July 22, 2021

**Re: McMahon Shopping Center
McMahon/Unser NW
Traffic Circulation Layout
Architect's Stamp 07-20-2021 (A11-D017)**

Nilo Salgado-Fernandez, P.E.
Senior Traffic Engineer, Planning Dept.
Development Review Services

UNSER & MCMAHON  
ENLARGED SITE PLAN  
ALBUQUERQUE, NM  
PROJECT #2063

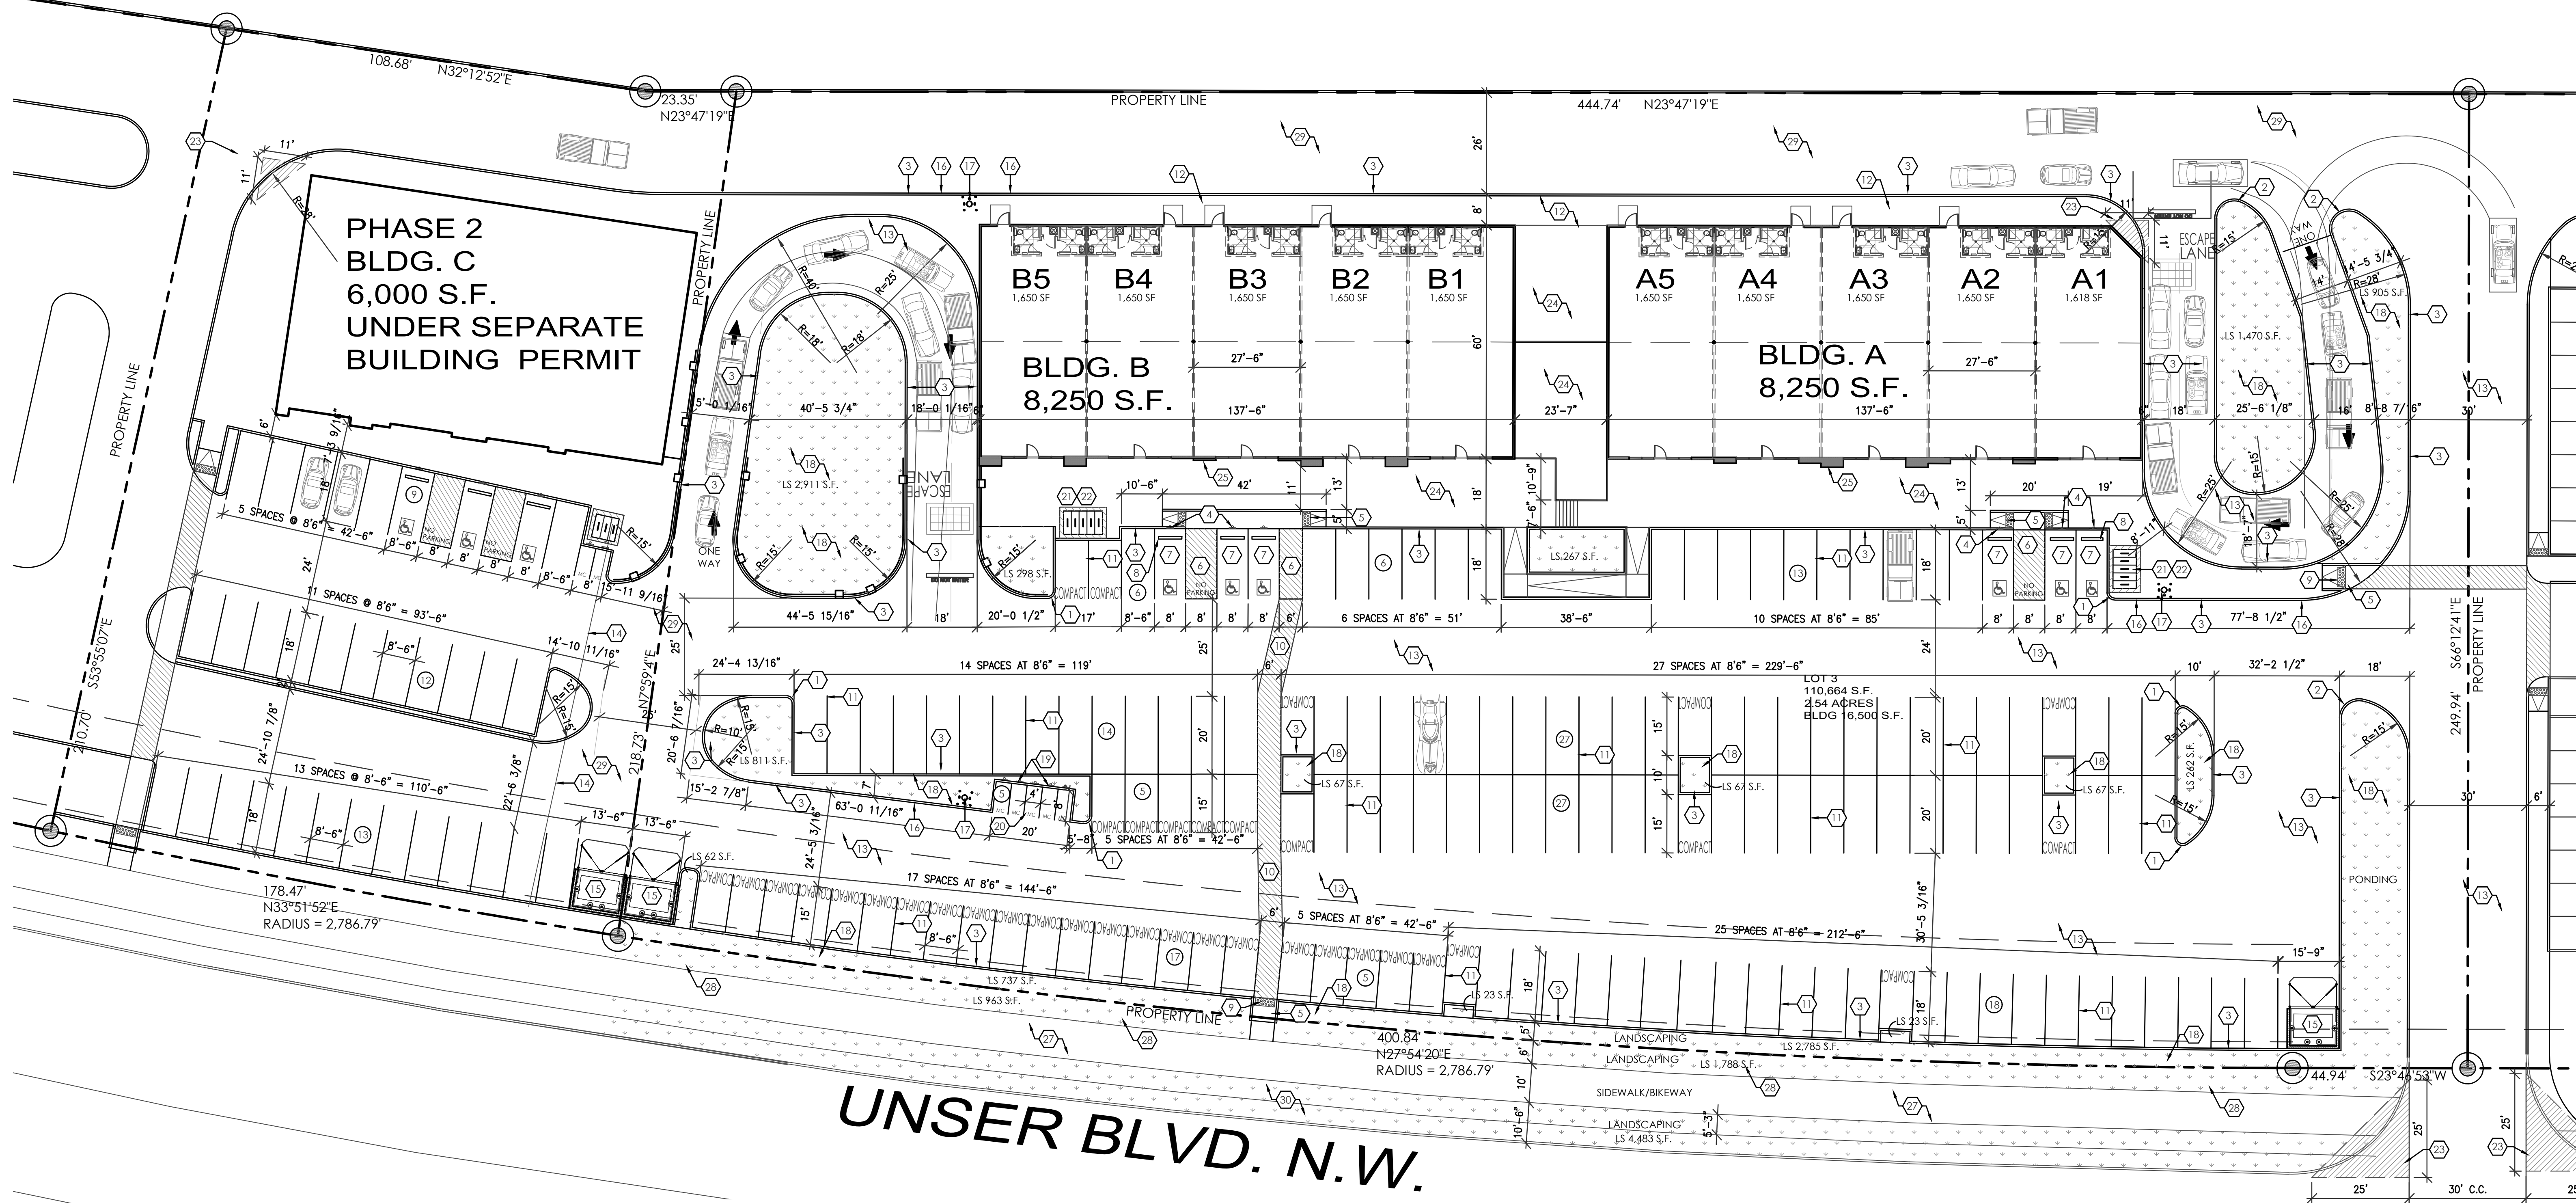
3. **Another access entrance/point is need to provide emergency accommodation for ingress/egress. This access can be provide off Bandelier, McMahon or any other access point deem necessary.**

4. How will you service the Main Circulation Road behind buildings A & B: **You show how a vehicle encroaches into the drive thru lanes which is a safety concern. Please address these concerns.**

8. Identify all existing access easements and rights of way width dimensions.
9. **Identify the right of way width, medians, curb cuts, and street widths on Unser Blvd NW.**

10. Please list the width and length for all proposed parking spaces. **Some dimensions are not shown.**

12. **ADA curb ramps must be updated to current standards and have truncated domes installed.**
13. Motorcycle parking spaces shall be designated by its own conspicuously posted upright sign, either free-standing or wall mounted per the zoning code. Label pavement MC.

14. **All bicycle racks shall be designed according to the following guidelines:**
- a. The rack shall be a minimum 30 inches tall and 18 inches wide.
 - b. The bicycle frame shall be supported horizontally at two or more places. Comb/toaster racks are not allowed.

15. **Bicycle racks shall be sturdy and anchored to a concrete pad.**
16. **A 1-foot clear zone around the bicycle parking stall shall be provided.**
17. **Bicycle parking spaces shall be at least 6 feet long and 2 feet wide.**

18. List radii for all curves shown; for passenger vehicles. **Radius for delivery trucks, fire trucks, etc. is 25 ft. or larger.**
19. Per the IDO, **a 6 ft. wide ADA accessible pedestrian pathway is required from the public sidewalk to the building entrances.** Please clearly show this pathway and provide details.

20. Per DPM, **a 6 ft. wide ADA accessible pedestrian pathway is required** from the ADA parking stall access aisles to the building entrances. Please clearly show this pathway and provide details.

21. **ADA 6ft wide Pedestrian continuity needs to be provided between buildings A & B**
22. The proposed ADA parking stall:
- **Ramp are only 5 ft width. 6ft is the requirement.**

- **The back of ramps are a safety concern (tripping hazard) for pedestrians.**

23. **Unser pathway: Provide widths of existing pathway.**
24. All one-way drives shall have "One Way" and "Do Not Enter" signage and pavement markings. Please show detail and location of posted signs and striping.

25. **The minimum drive through lane width is 12 feet with a 25 foot minimum radius (inside edge) for all turns. (A 15 foot radius can be used with an increase in lane width to 14 feet). Please dimension all lane widths and radii.**
